**State Significant Development Application and Variation of the Sydney Cove Redevelopment Scheme for the “*Remediation, Renewal and Adaptive Re-Use of Campbell’s Stores*”, The Rocks (SSD 7056)**

We write in response to the above development application (DA) and request to vary the Sydney Cove Redevelopment Authority Scheme (SCRAS) submitted to the Minister for Planning by Tallawolodah Pty Ltd for proposed works to the Campbell’s Stores at The Rocks.

This objection has been prepared by SAKE Development with GMU Urban Design and Architecture; and Clive Lucas, Stapleton & Partners Heritage Consultants on behalf of the owners and residents at 8 Hickson Road The Rocks, located directly opposite the Campbell’s Stores. This letter has been prepared for the Owners Corporation (Strata Plan No. 70158). Specific urban design and heritage objections are attached and provided under separate cover.

*Proposed amendment to the height diagram*

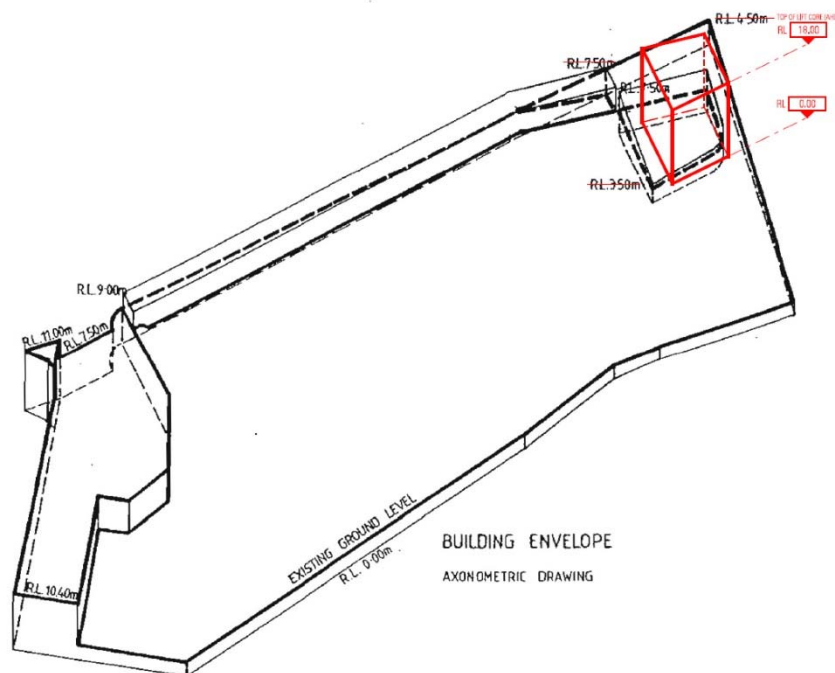
The proposed new glass building does not comply with the Building envelope control as shown on the axonometric drawing provided on the SCRA Scheme. The current control would only allow a single storey building. The proposal exceeds the height restriction on the **foreshore frontage by 14.5m, more than 250%** and on the Hickson Road elevation by **10.5m, or 140%**. Along the foreshore, the applicant is seeking to increase the height from RL3.5 to RL18, more than 5 times the current permissible height limit.
